InterContinental Hotel and Transport House, Sydney – Amended Proposal for Concept Development Application (Staged Development) for Alterations and Additions (SSD 7693)

As a resident of the Astor at 123 Macquarie Street, Sydney, I object to the development proposal SSD 7693. In doing so I adopt the submissions made by Elizabeth Gavey, chair of the Astor Pty Ltd.

SETBACK DIAGRAM | VIEW FROM NORTH-EAST

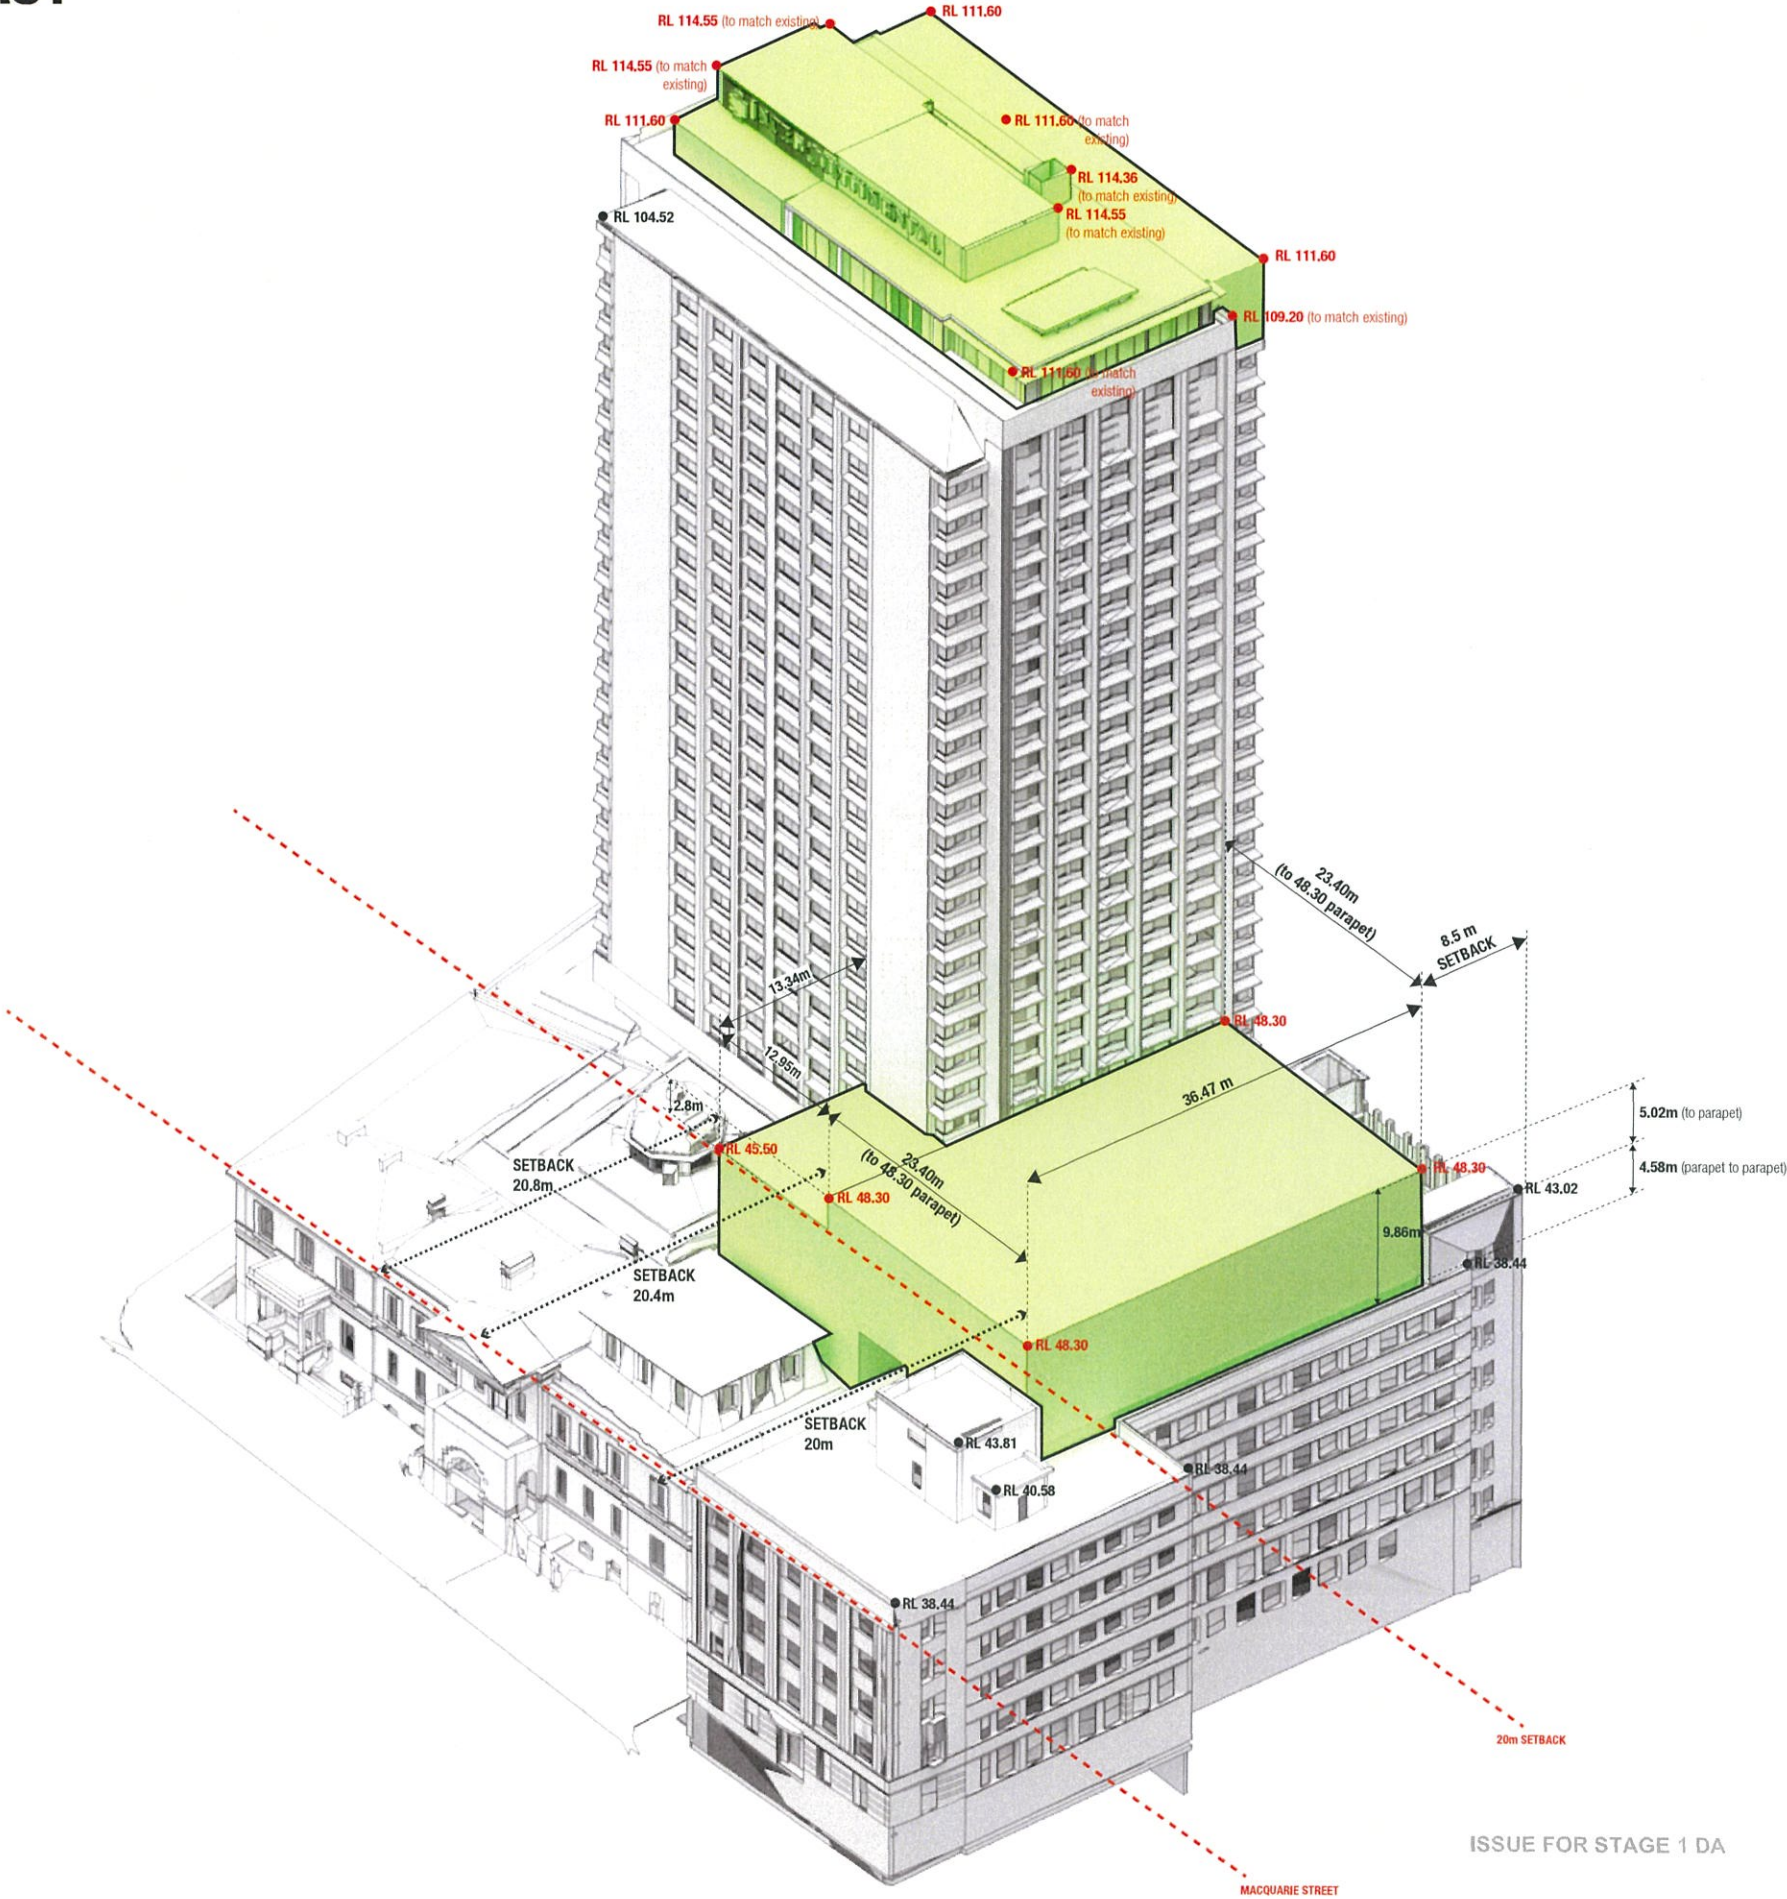
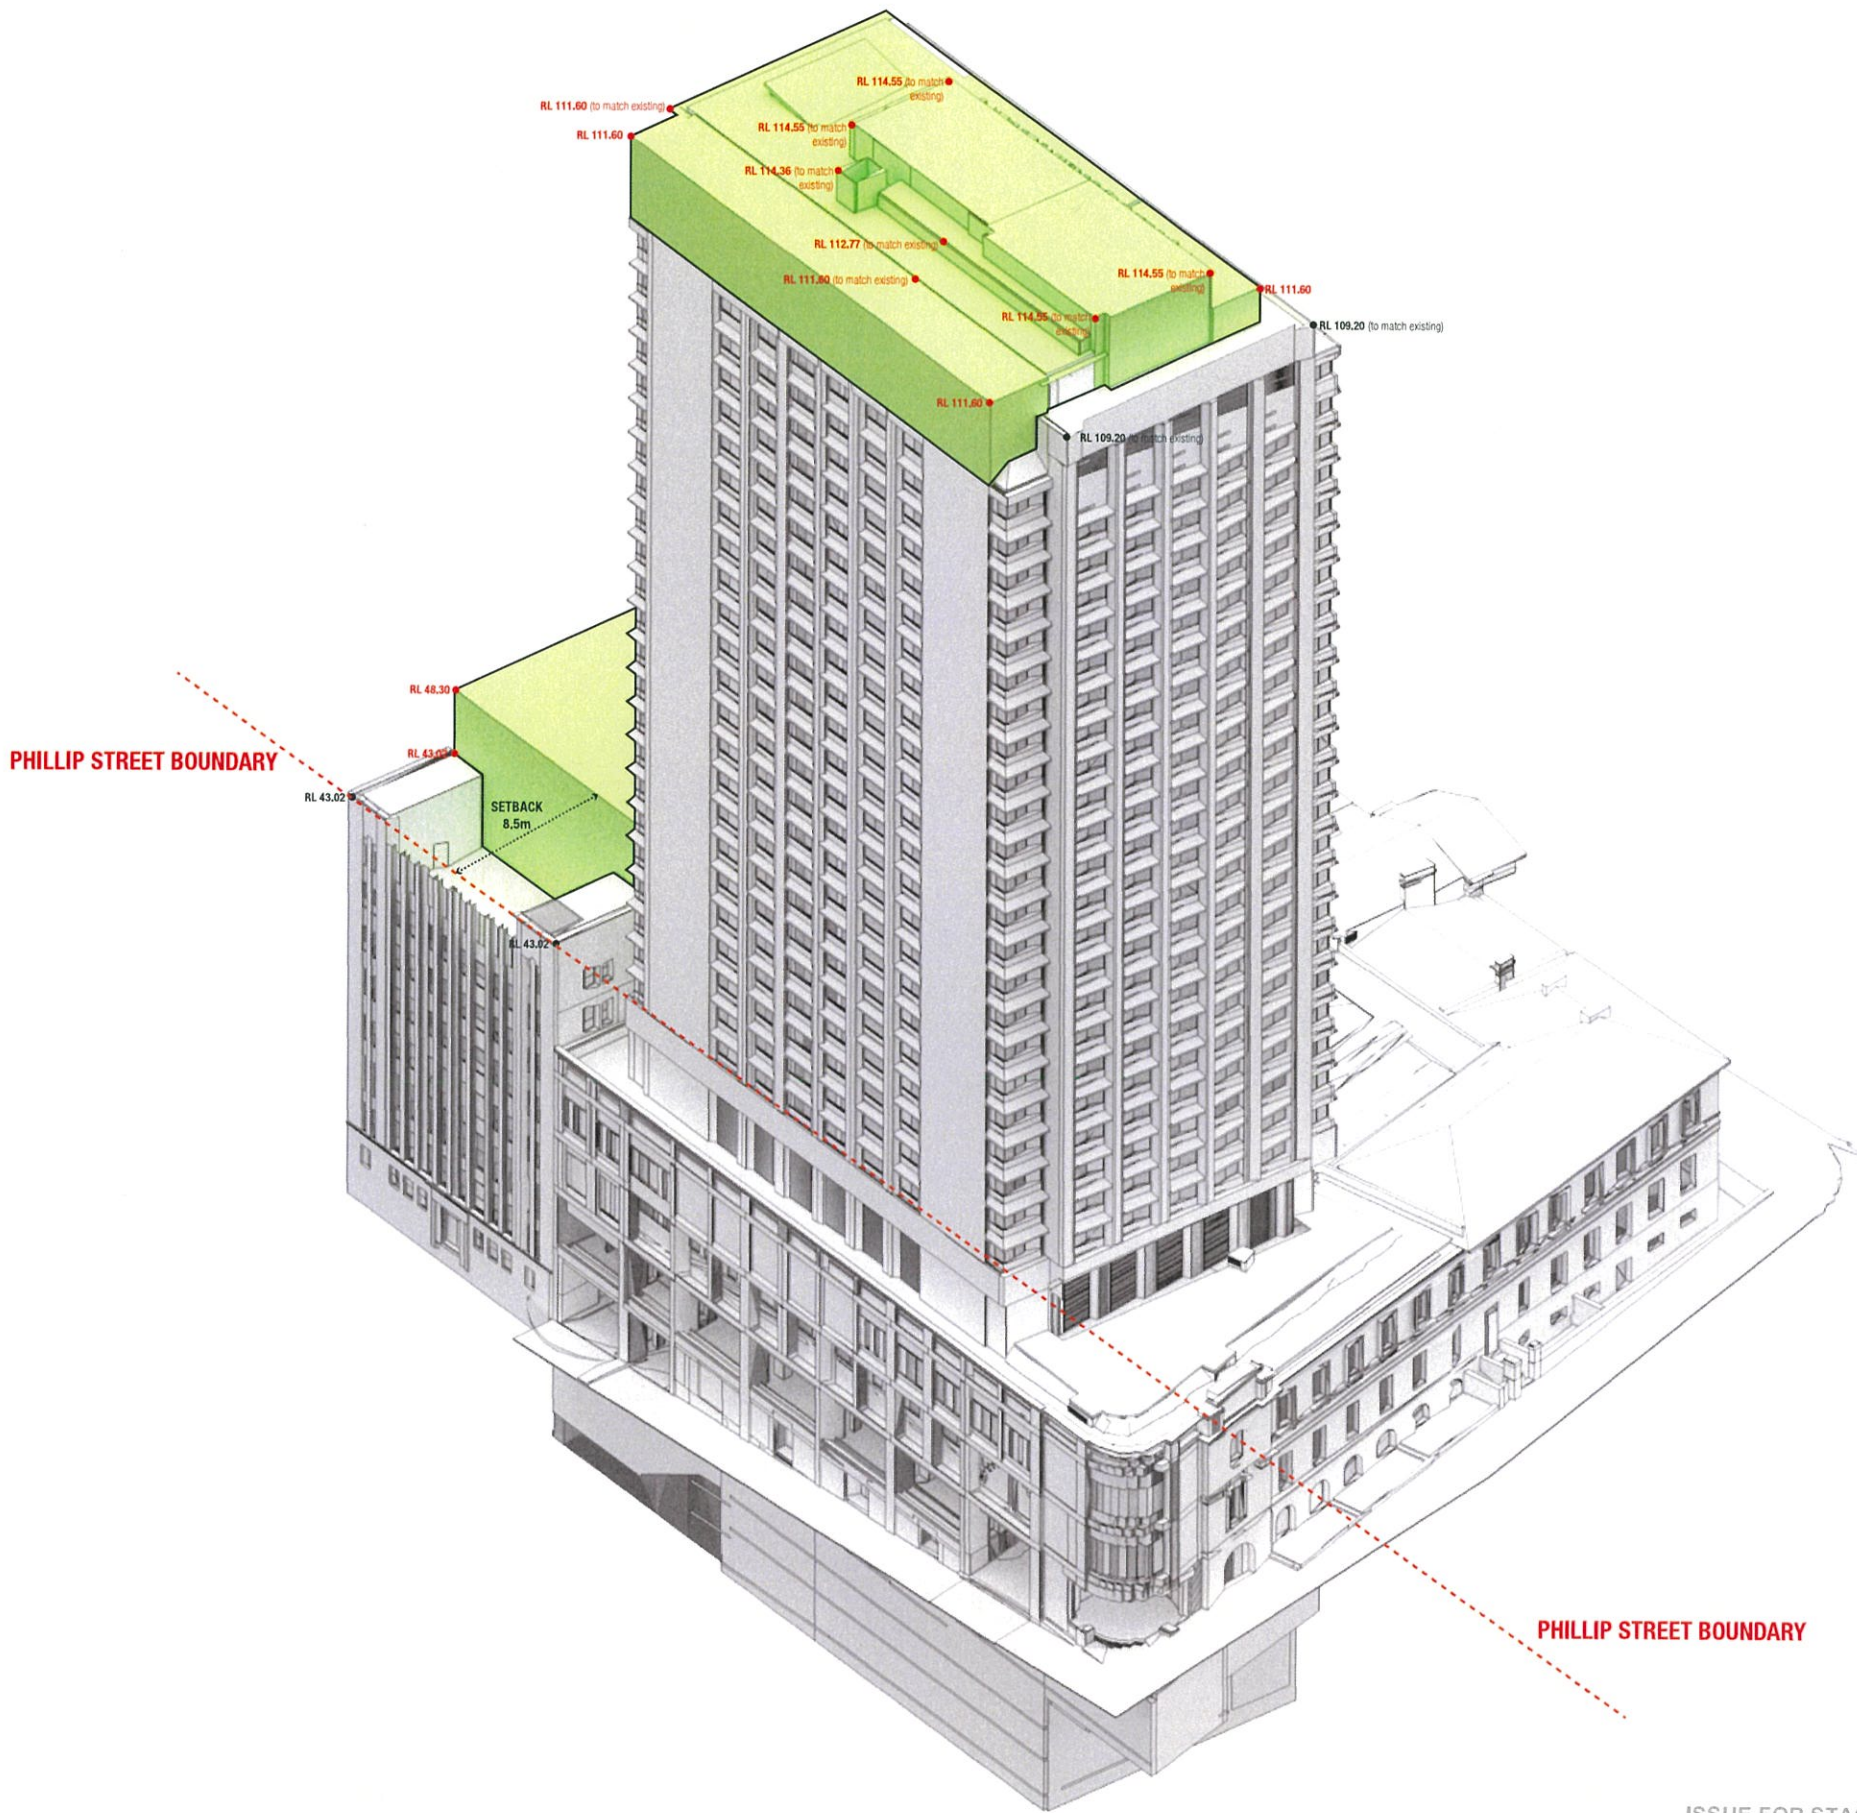
1. Despite the amendments that have been made to the Concept Development Application, the failure of the building envelope to comply with mandated setbacks results in an unacceptable adverse visual impact on the heritage buildings in the area - heritage architecture and streetscapes are overwhelmed, views are lost and existing smaller scale buildings are "hemmed in".

3. Specifically, the proposed development should comply with the 30 metre front setback control from Macquarie Street in the Special Character Area.
4. To not comply with existing setbacks will overwhelm and detract both from the heritage buildings on which the proposed building envelope sits, and generally, the heritage streetscapes in the Macquarie Street Special Character Area.

7. Even though there would be a minor impact on water views from some apartments, this is unacceptable as:
 - 1) The impact only occurs because the proposal does not comply with the requirement of the Development Control Plan for a 30 metre setback from Macquarie Street. There is no public benefit from the reduced setback – and arguably there is a public detriment in terms of adverse heritage impacts.
